**Consultation Response from KC,
Trees**

2024/90730 Land between, 30 and 60, Commercial Street, Slaithwaite, Huddersfield, HD7 5JZ

Erection of seven dwellings and associated works

Date Responded: 28/03/2024

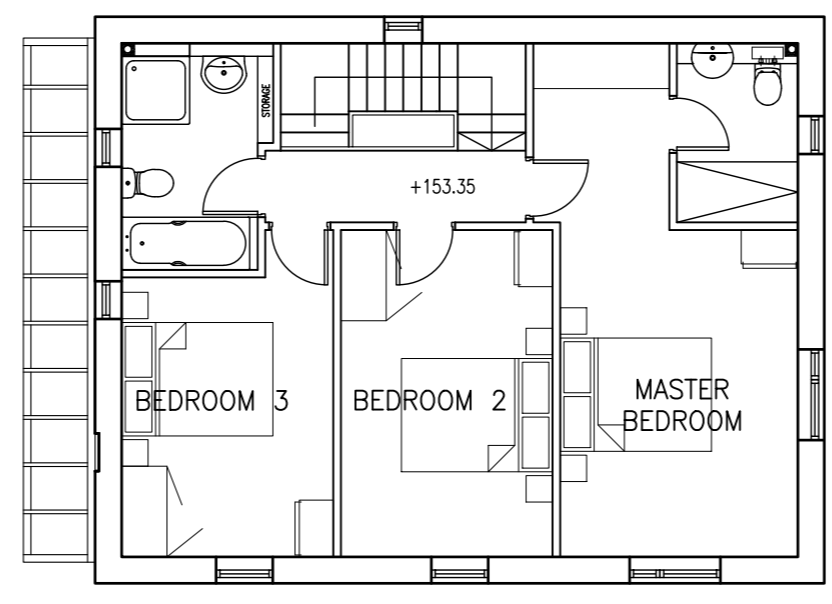
There are no protected trees on site and all existing trees are being retained. Dwelling number 7 has some patio paving to the rear that may just enter the root protection zone of the adjacent tree, but the effects would be negligible. No further comments and no objections.
